Grandview Reserve Project

Testimony on:

Potential Downstream & Floodplain Impacts to Adjacent Property Due to Master Development Drainage Plan for East Fork and East Fork Tributary of the Gieck Ranch Drainage Basin

Scott D. Reid & Susan K. Charles

EXISTING EX1

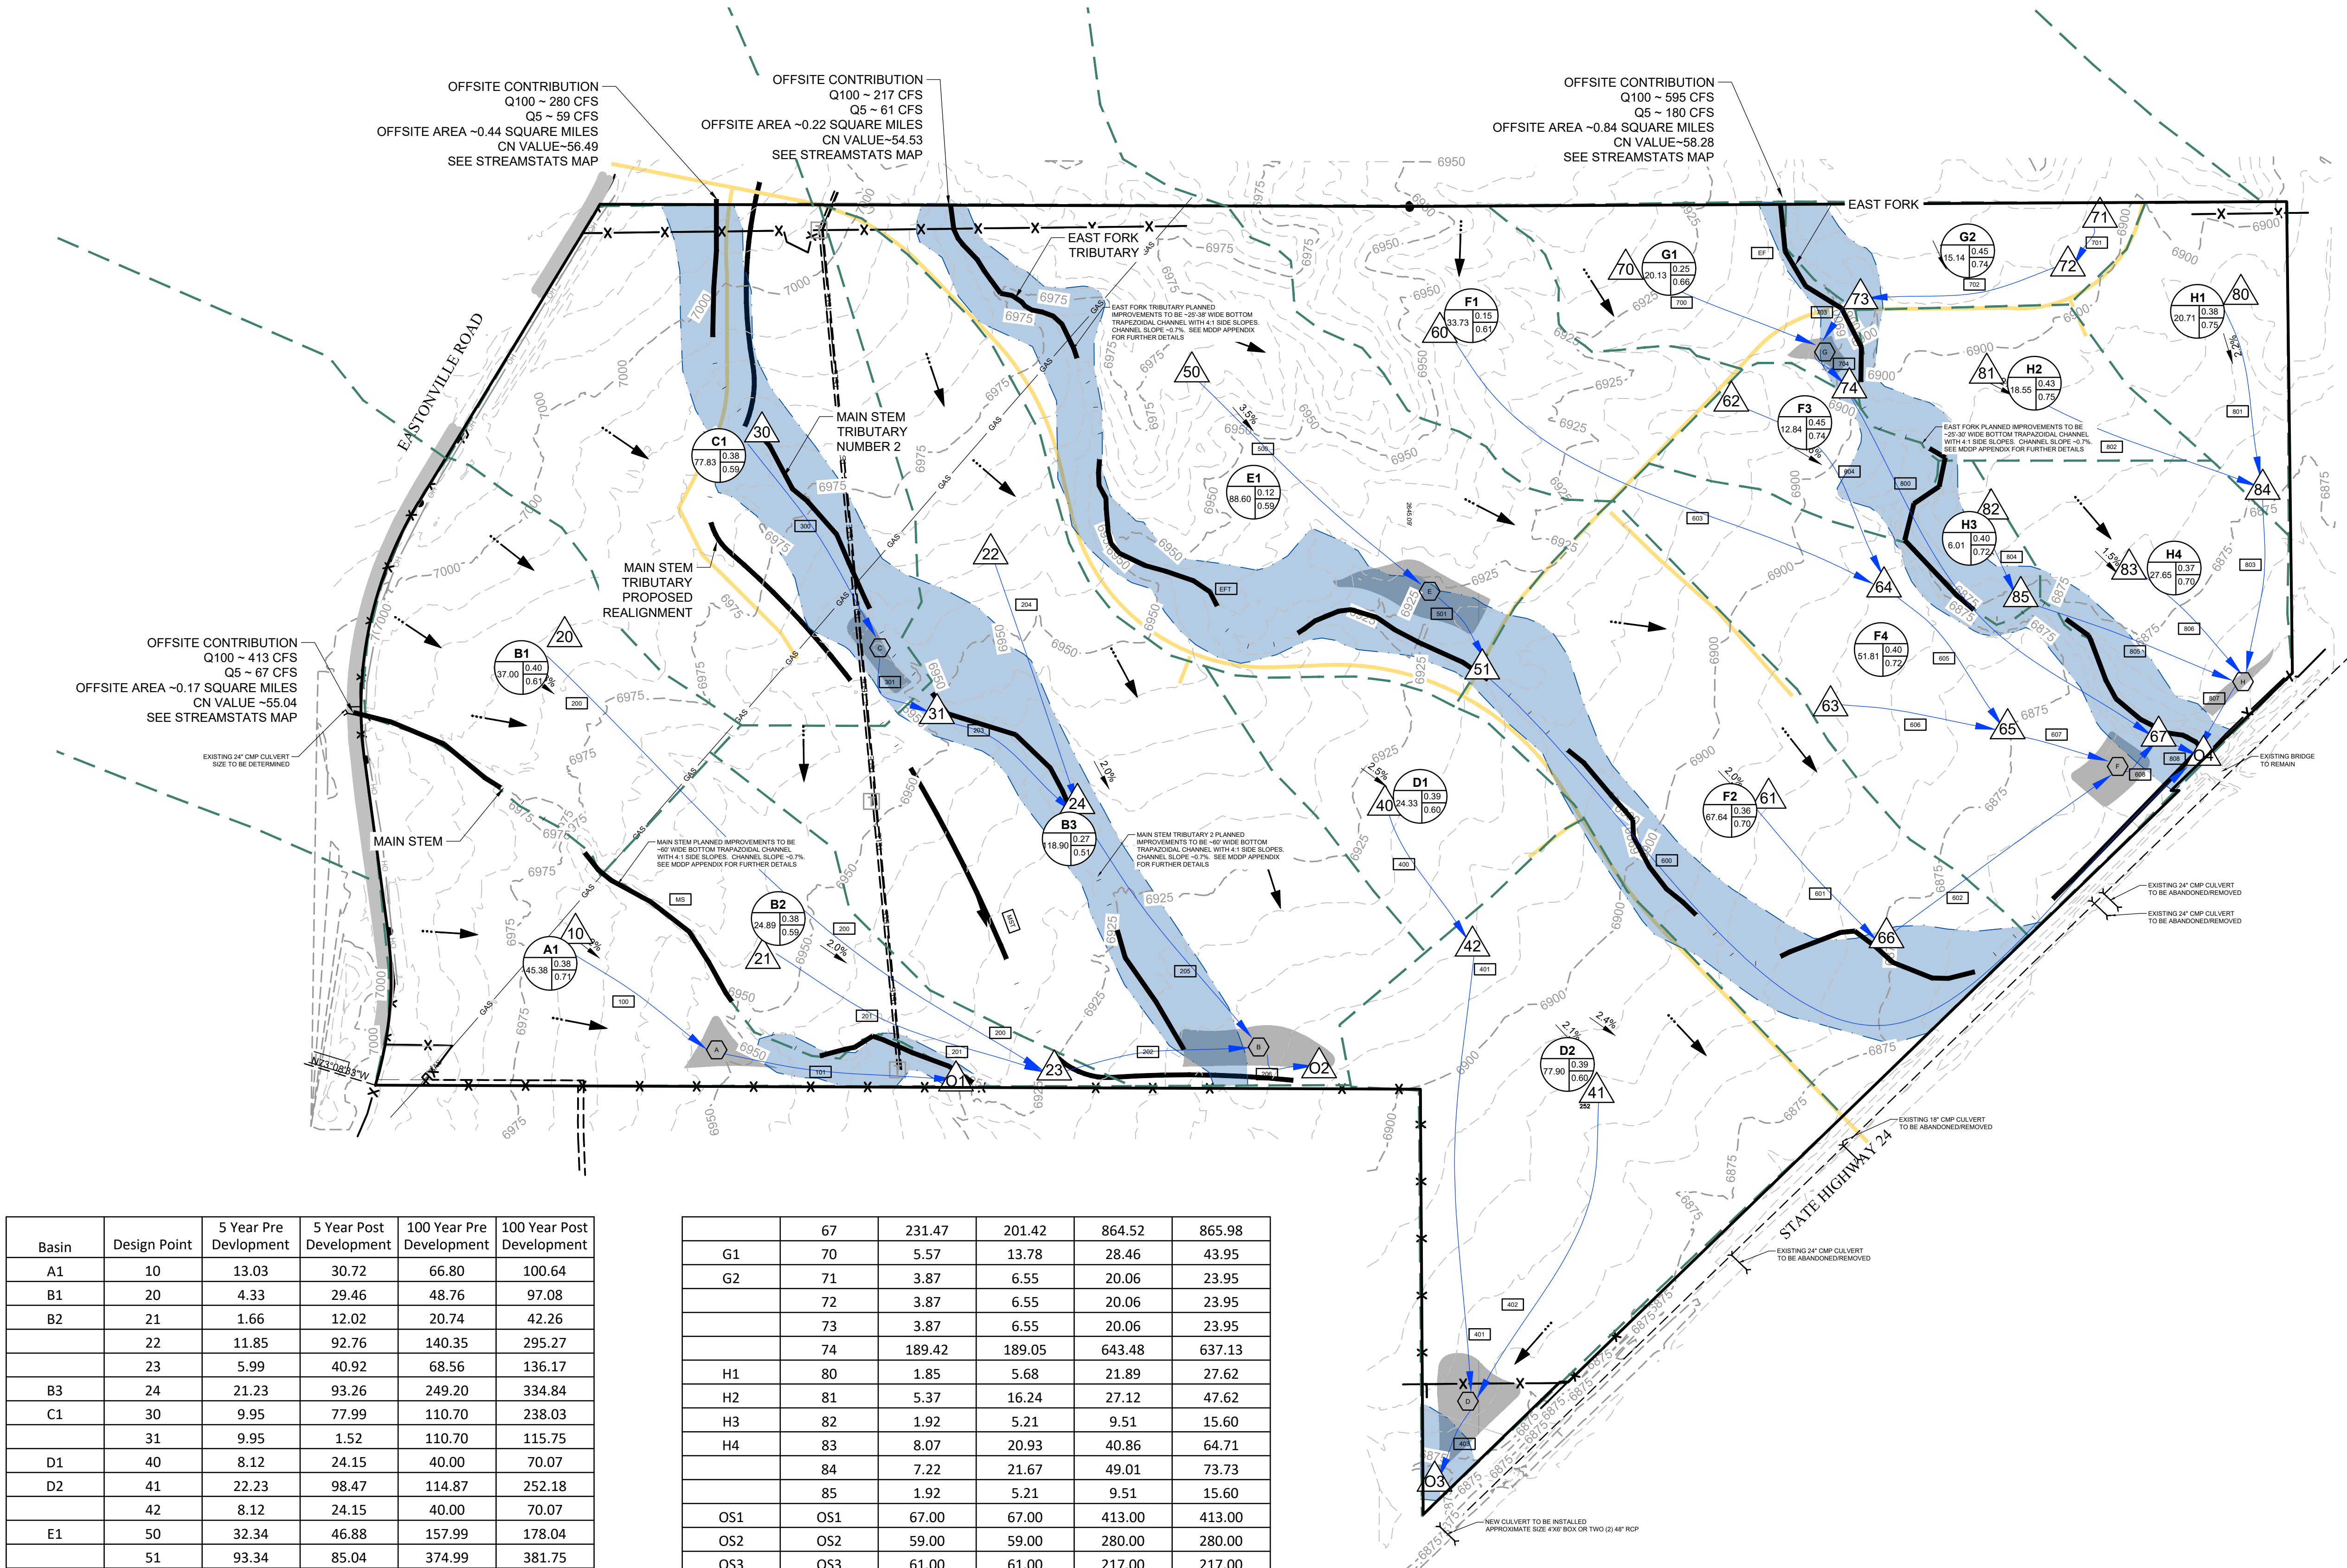
The current MDDP reports maximum predevelopment and post-development ET outfalls to our property in the table shown in Figure 1 below (as Outfall 4). We are pleased to see lower than historical 'outfall' values for the EF, the major and potentially most vulnerable drainage channel on our property. However, we still have questions and concerns related to this plan. These are essentially the same as for the 2019 MDDP. For the current proposal, peak outflow velocities are reduced but we are cautioned that the EF will be subjected to increased volumes that will likely disturb the drainage channel and require mitigation. There is no summary provided to characterize the anticipated increased volumes under various scenarios.

We are assuming 'outfall' is synonymous with 'offsite flow' in this instance; if so, the predevelopment values shown in Figure 1 are quite different than what is reported in other documents for the EF (see Figure 2 below). Additionally, there is no reported offsite flow from the EFT. This appears to be explained by the statement in the 2020 Master Development Drainage Plan (page 11, PDF page 14):

The above comment in the 2020 MDDP contradicts previous studies; we cannot concur that this is the currently existing condition as claimed here. If all of the runoff from the East Fork Tributary joined and exited the Grandview property through the East Fork, the offsite runoff for the East Fork Tributary would be zero and the East Fork Q5 and Q100 values would be the sum of what is shown in the table in Figure 2.

PROPOSED DR1

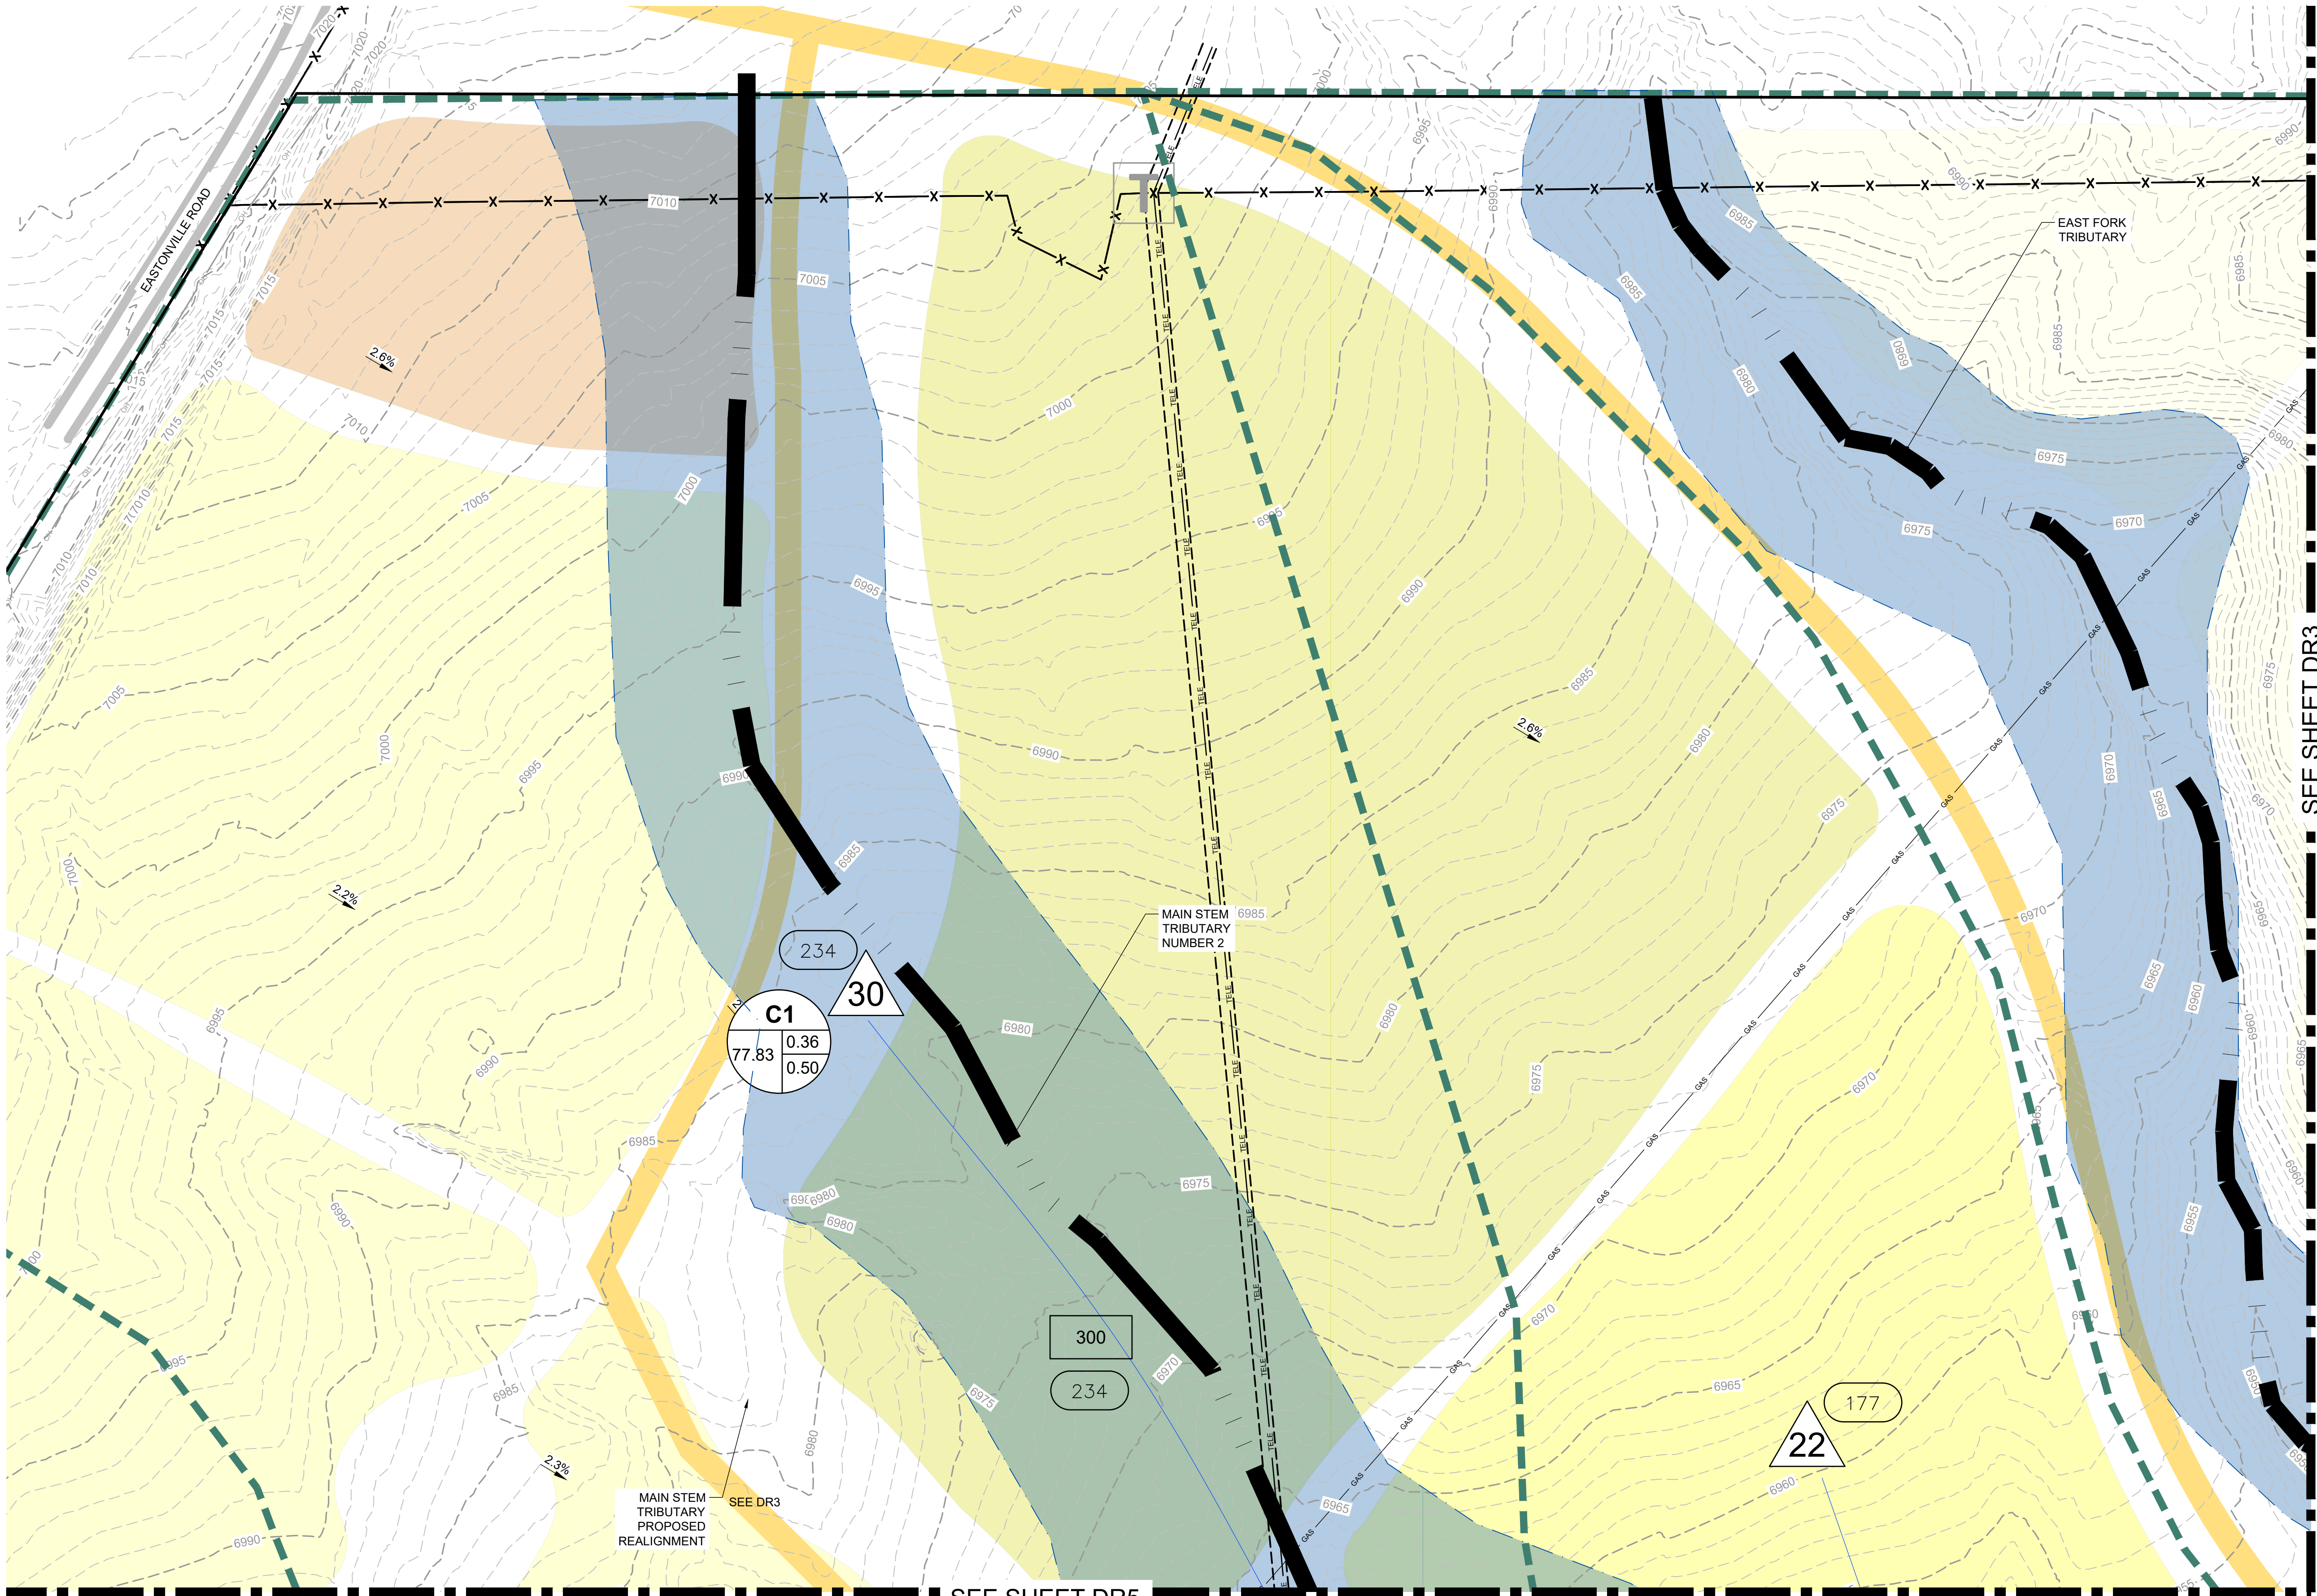
The East Fork tributary (EFT) crosses the north property line and are conveyed through the site via a natural channel. The channel has been mapped as a Zone A floodplain per the existing FIRM panel. *There is no existing crossing for this section of the drainage channel below Highway 24 and instead the flows are conveyed to the north east towards the East Fork Upper (EF).* **Emphasis added.**

This lack of runoff to our parcel from the EFT raises the same concern for the impact on existing vegetation in the western part of our parcel containing the EFT channel that we outlined earlier in regard to the 2019 MDDP.

It is evident that new revisions to the floodplains will be required for the currently proposed development. We assume this will involve a similar strategy to what JR Engineering proposed for the EFT floodplain. The current MDDP seems to assume the 2019 proposed changes to the EFT are already *the current condition*. Is this an oversight, an incorrect assumption, or are you proposing a diversion connection/channel that isn’t shown on the current MDDP?
